DECISION DELEGATED TO HEAD OF PLANNING

Application No: H02-0522-25 **Applicant:** L Adrian
Proposal: Demolition of existing rear structure and erection of single storey rear extension, creation of Juliet balcony, erection of new front porch, internal alterations & erection of single storey pool house with indoor pool
Location: 3 Railway Cottages Martins Road Crowland
Terminal Date: 3rd October 2025

CASE OFFICER ASSESSMENT

POOL HOUSE, FLOOR PLAN, SCALE 1:50

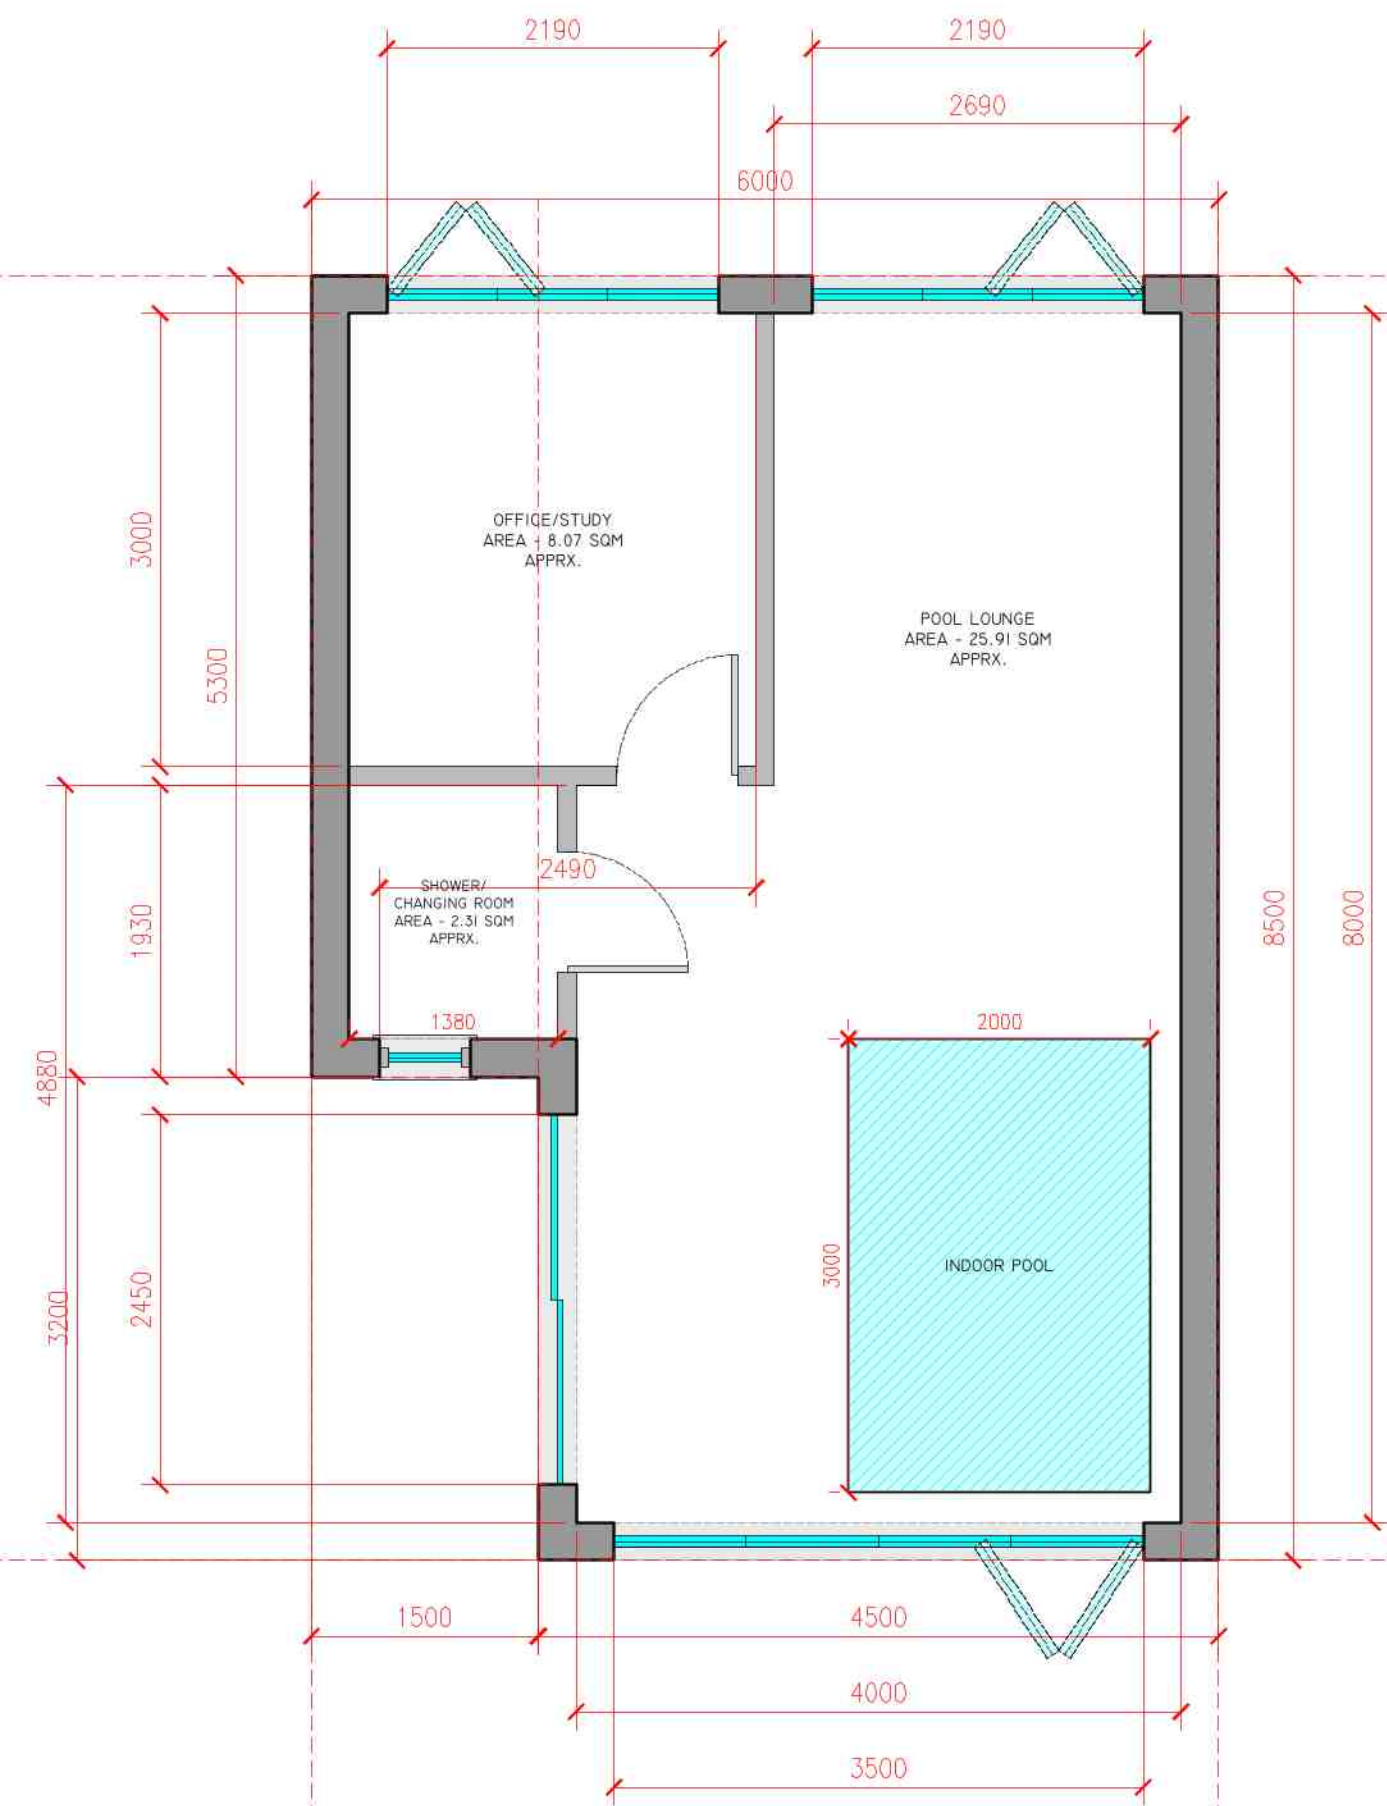
The pool house would be set to the rear of the site, around 2575mm from the rear boundary. Internally it would feature an office/study with a shower/changing room directly behind. The main feature of this building would of course be the indoor pool and pool lounge area. There would be a large array of bi-fold doors across the front elevation facing the host dwelling with two separate features to the rear. This would provide natural light into all rooms. As previously mentioned, it would have a height of 2700mm and would therefore exceed permitted development parameters by 200mm. In any case, this additional height would not result in any material harm caused to the street scene or area and fits well within the plot in relation to the host dwelling. As the material would also match this further ensures its acceptability in this regard.

should be no material loss of privacy from the proposed pool house either, there are ample trees and boundary treatments across both side elevations whilst there are no properties to the rear. The front windows would most likely only look into the host site itself.
